City of Albuquerque

RE: REVISED ENGINEER'S CERTIFICATION FOR LAS MARCADAS SUBD (C-12/D2B)
RECEIVED FEBRUARY 3, 1995 FOR FINANCIAL GUARANTY RELEASE
ENGINEER'S STAMP DATED 9-28-94

RE: DRAINAGE REPORT FOR LAS MARCADS SUBDIVISION, (C12-D2B), ENGINEER'S
STAMP DATED JULY 30, 1993

Re: Tract A-3 Las Marcadas, Traffic Circulation Layout
Engineer's Stamp dated 9-18-03 (C12/D2B)

TRACT A-3, LAS MARCADAS SUBDIVISION
DIMENSION SITE PLAN
ALBUQUERQUE, NEW MEXICO
BLI PROJECT 03521

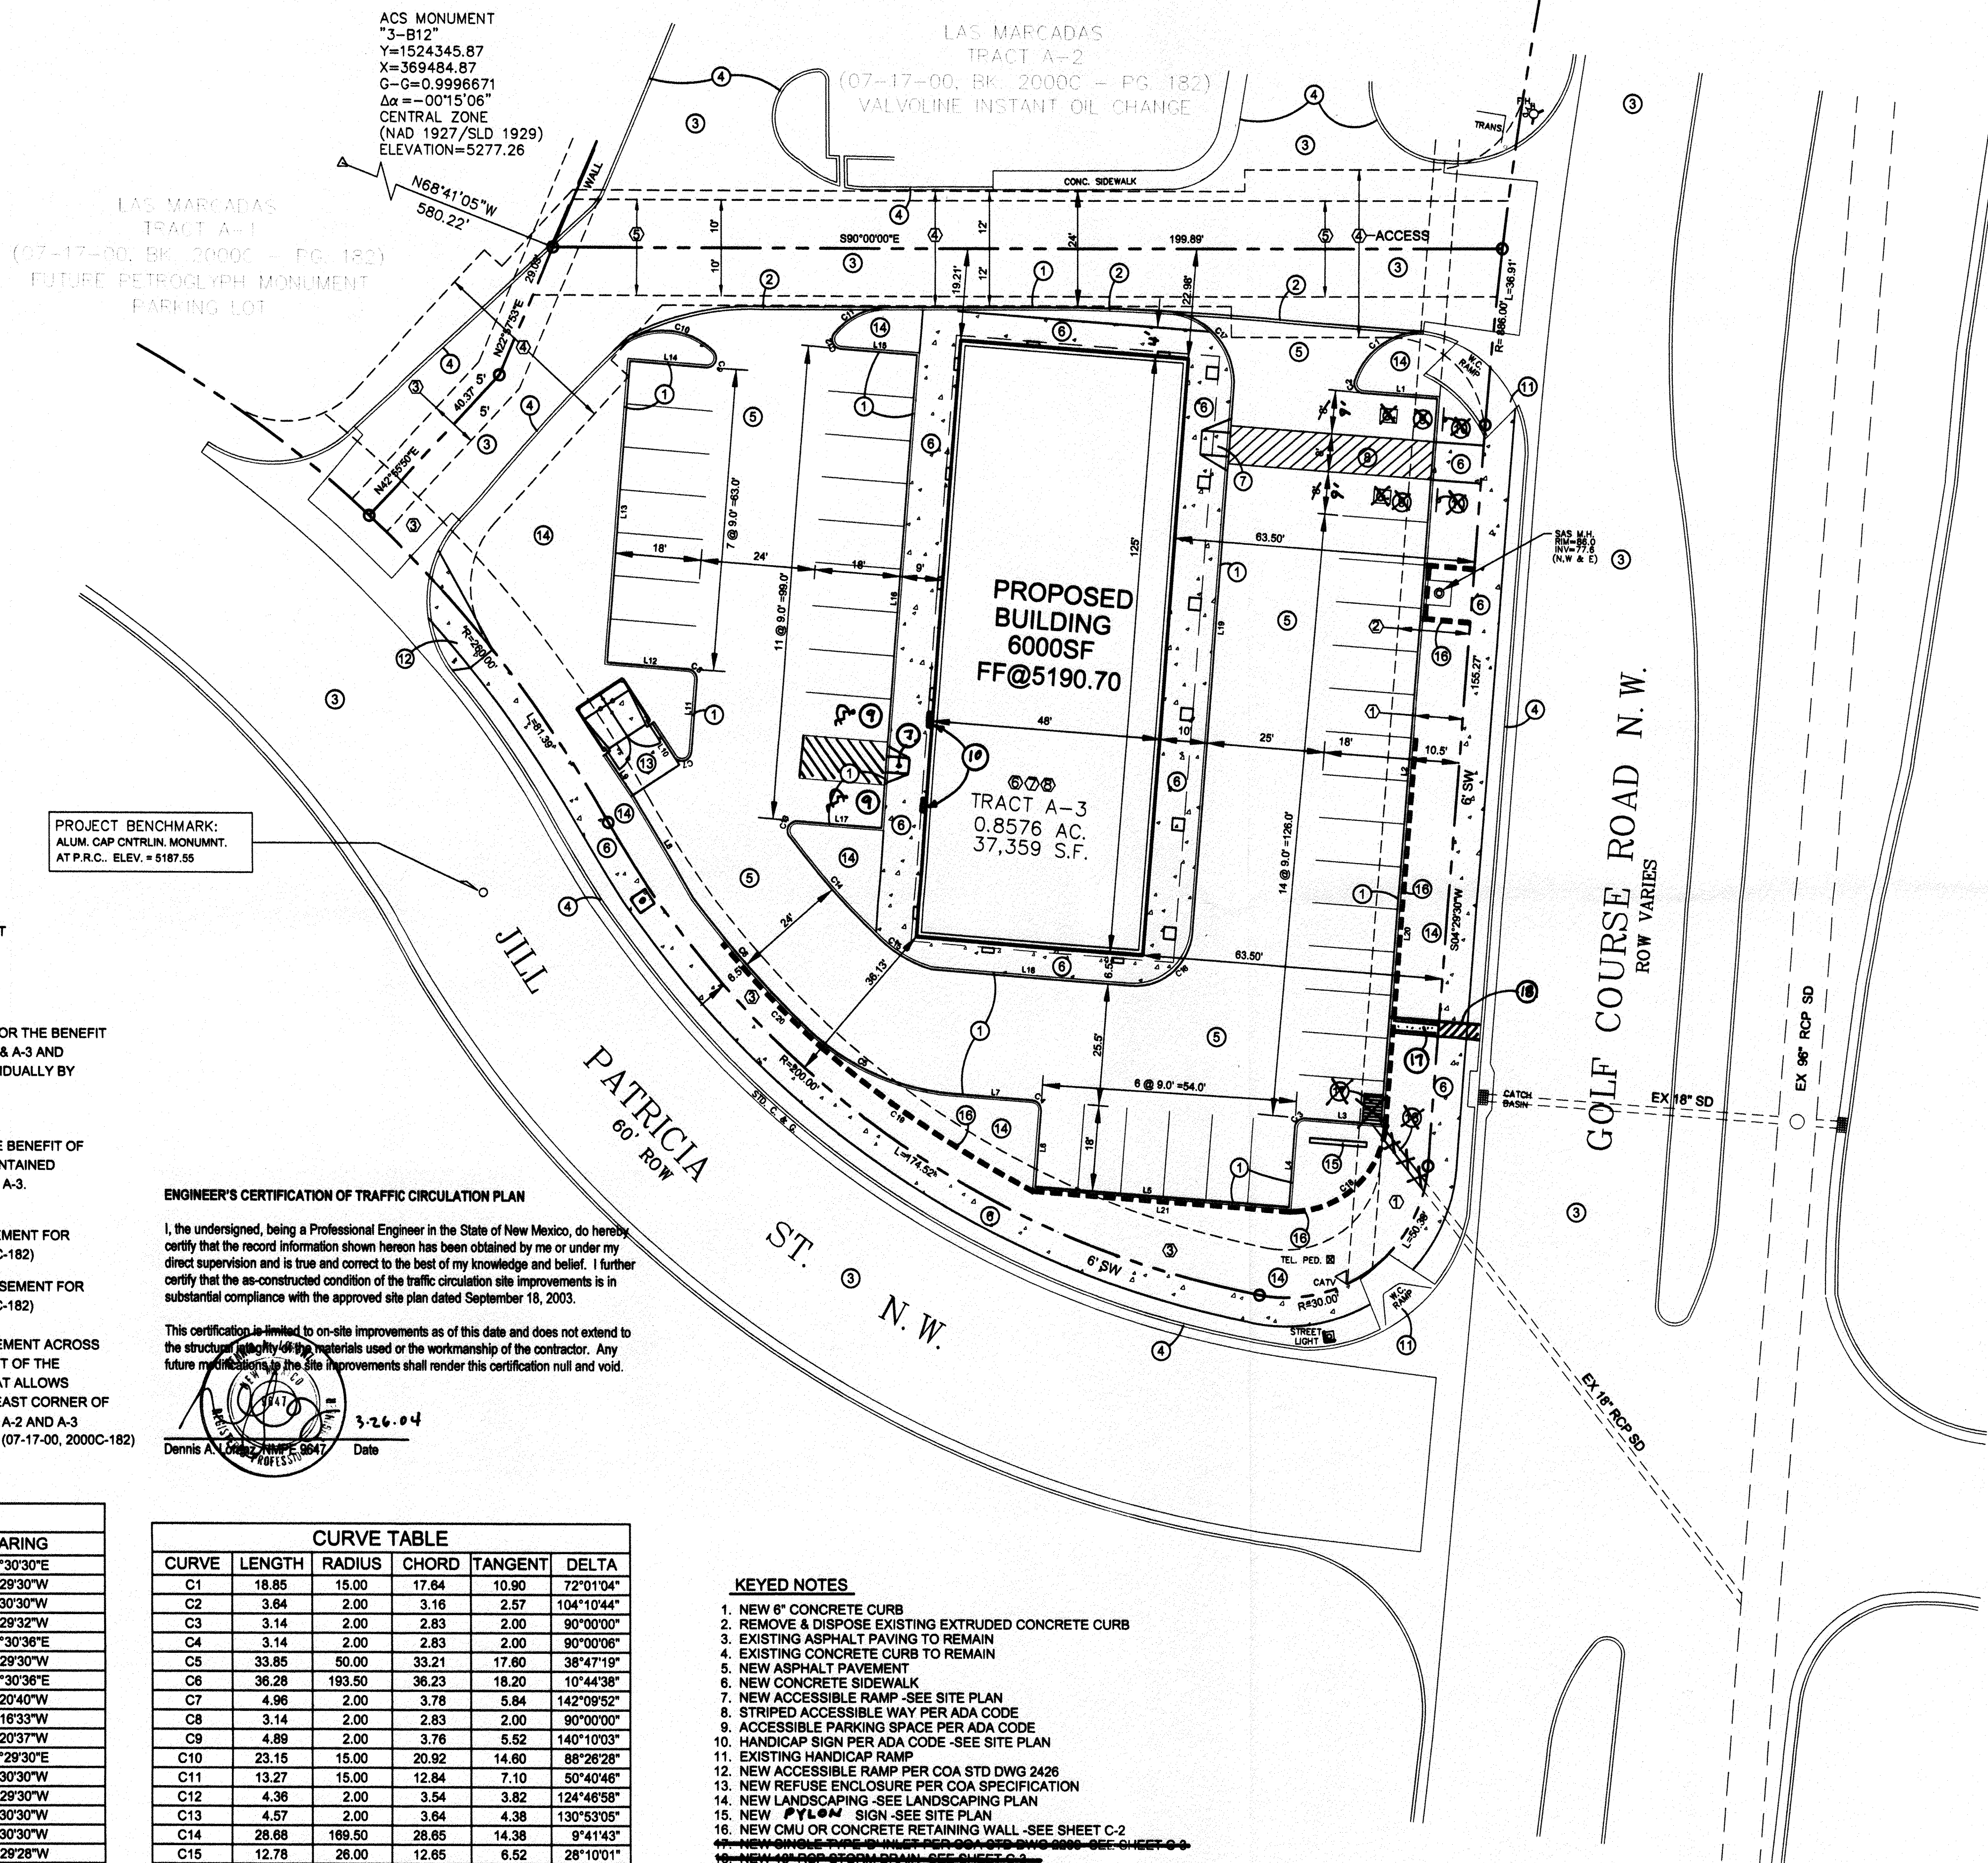
1. Curve 16 will have a radius of 15 feet.
2. The location of the handicap spaces will be revised per zoning.
